CITY OF ALBUQUERQUE

Re: Zocalo
501 Coal Ave. SW
Traffic Circulation Layout
Engineer's 12-19-17 (K14-D112)

Based upon the information provided in your submittal received 12-21-17, the above referenced plan cannot be approved for Building Permit until the following comments are addressed:

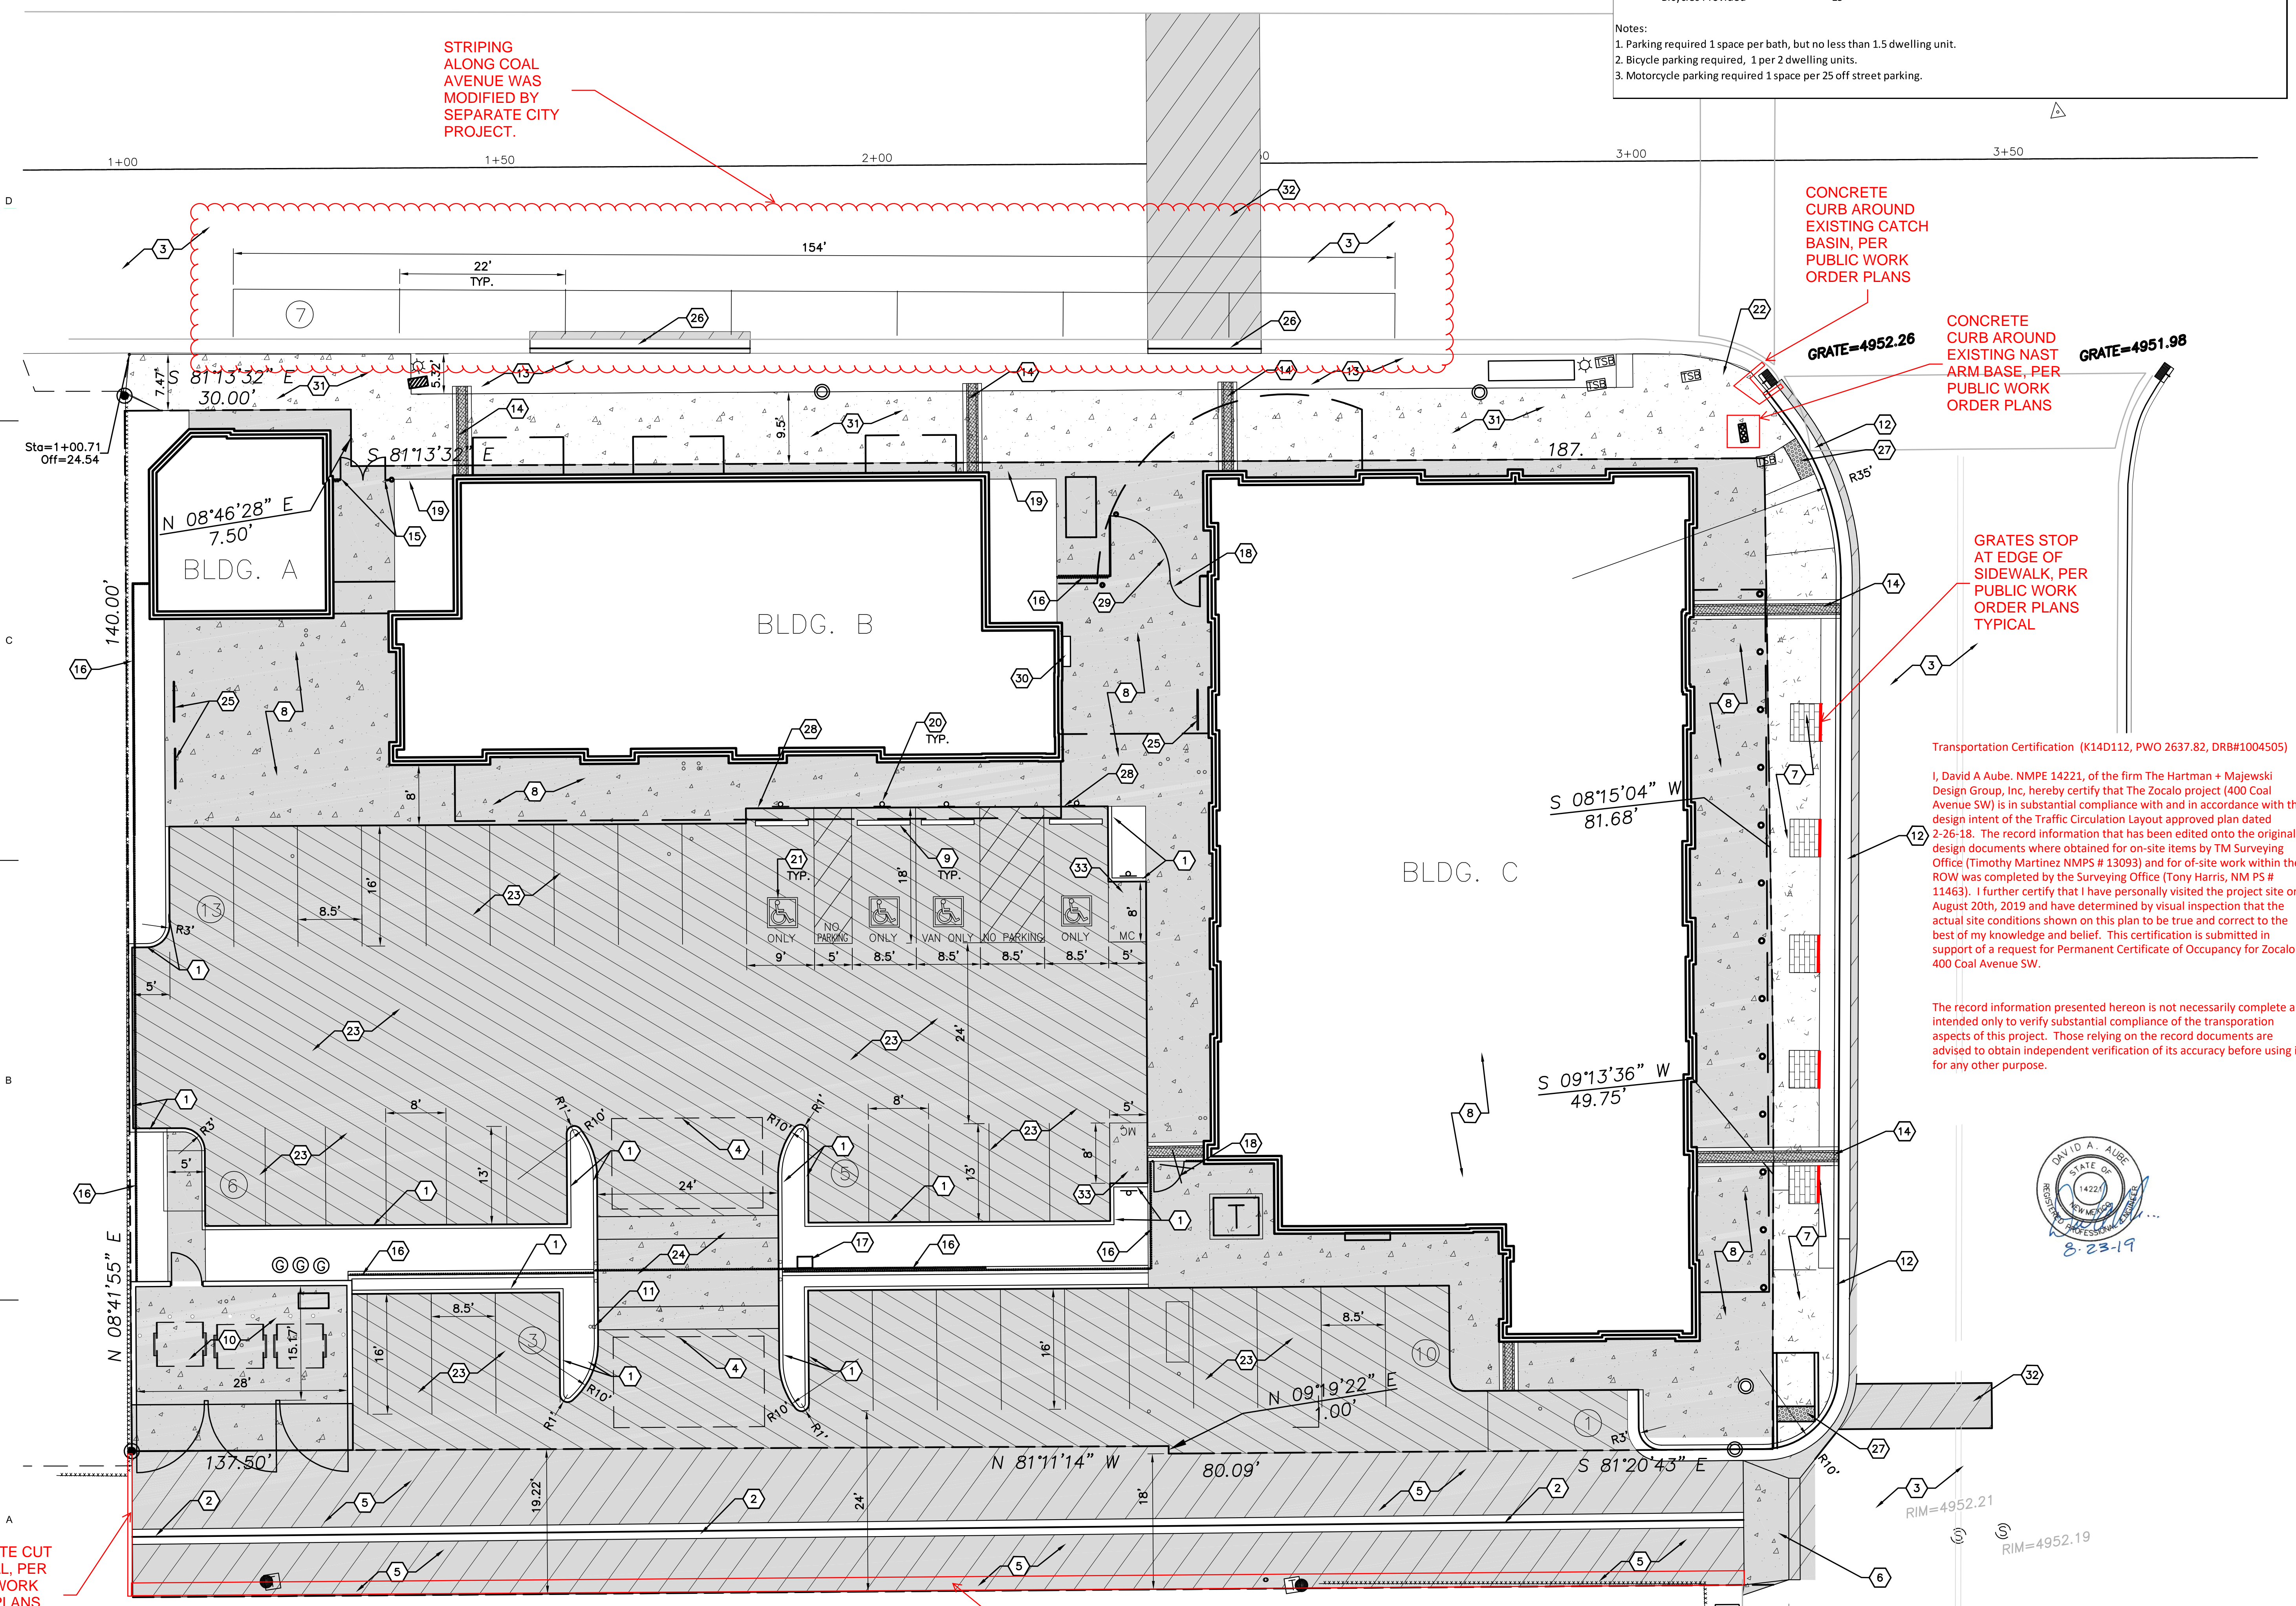
1. Motorcycle parking spaces shall be designated by its own conspicuously posted upright sign, either free-standing or wall mounted per the zoning code.
2. On-Street parking credit to fulfill zoning's parking requirement must be requested and approved by the Traffic Engineer, Racquel Michel prior to TCL approval. The application requires at least 45 working days. On-street parking credit is based on available parking along public right-of-ways fronting the property. The business will only be granted 50% credit for available street parking.
